CITY OF ALBUQUERQUE

Re: DEL TACO – EAST CENTRAL
10015 Central Avenue NE
Approval of Permanent Certificate of Occupancy (C.O.)
Engineer's Stamp dated 08/22/2006 (K-20/D57)
Certification dated 1/12/2007

Re: Certification Submittal for Final Building Certificate of Occupancy for
Del Taco, [K-20 / D57]
10015 Central Avenue NE
Engineer's Stamp Dated 12/22/07

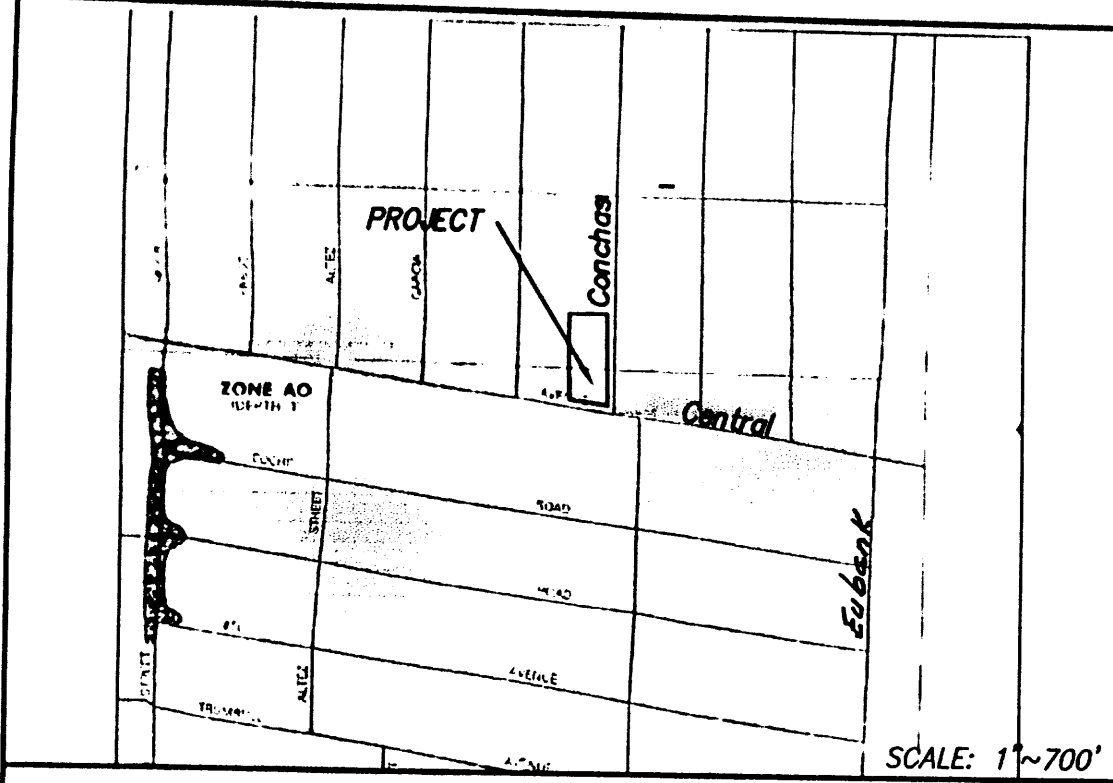
The TCL / Letter of Certification submitted on December 22, 2006 is not sufficient for acceptance by this office for final Certificate of Occupancy (C.O.). A 60 day Temporary C.O. has been issued until the following items has been addressed: wheel ramp at the corner of Central and Conchas needs to reflect ADA requirements (transition slope on Central doesn't meet the 12:1 max); site entrance on Conchas was not constructed per approved site plan and is incomplete (curb from site doesn't transition into header curb from ramps); and all ramps within COA ROW need to have truncated domes (detectable warning surfaces) per ADA guidelines.

1. Label and provide adequate signage for the drive-thru.
2. Provide the curve data for the drive-thru.
3. Label the southern most handicapped parking stall as van accessible.
4. See plans for additional comments.

GRADING & DRAINAGE PLAN

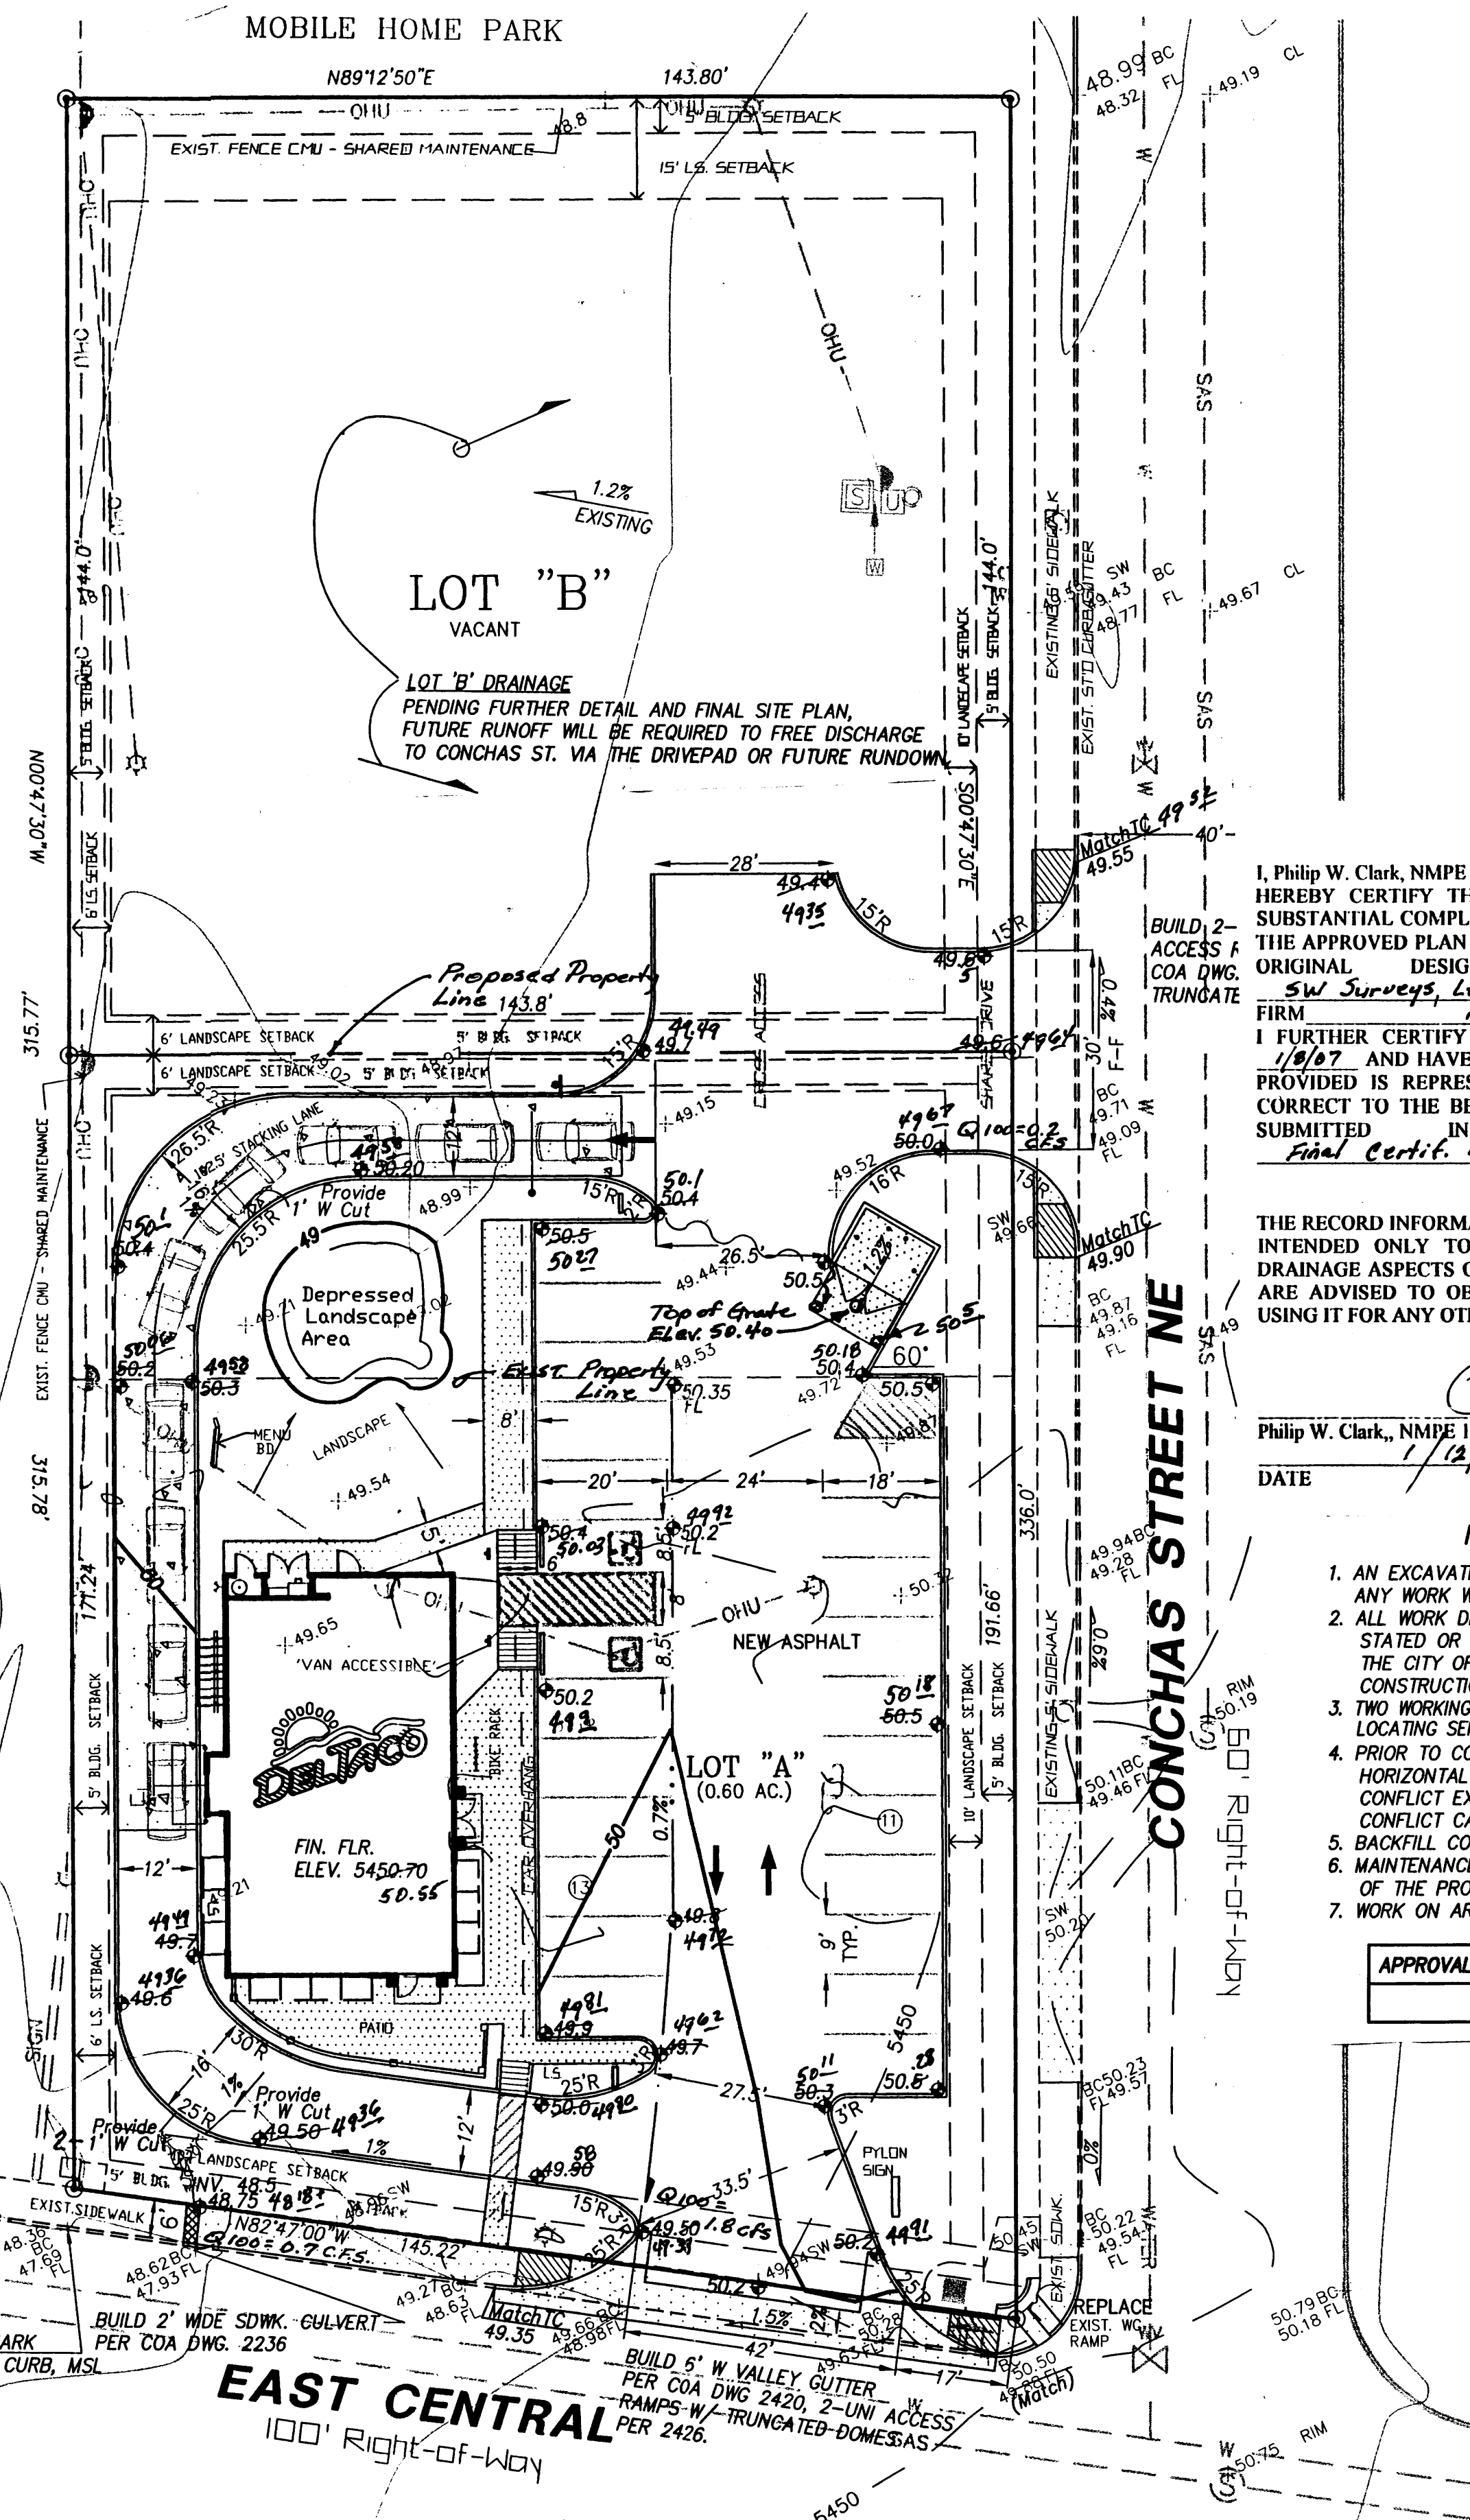
Upon review of the information provided in your submittal dated 6-27-06, there is one (1) issue which must be addressed prior to approval for Preliminary Plat or Building Permit. Specifically, runoff generated by trash enclosures may not be routed into storm drains. Drains to the sanitary sewer collection system must be included in the site work. As such, a detail of the trash enclosure with the drain and associated spot elevations must be shown.

1. The appropriate SO#19 notes must be added. Please see the attached copy of the approved notes.
2. Quantify the amount of flow exiting each drivepad.
3. Define what changes you plan on making with a new plat. Call out the existing and proposed lot line. Clarification of this within the write up would be helpful.
4. You must provide written permission from the adjacent property owner prior to proceeding with any work on Lot B.
5. Since you are changing the lot layout, you must define the existing and proposed drainage conditions for Lot B. Provide elevations. How much flow will enter Conchas Street from Lot B?
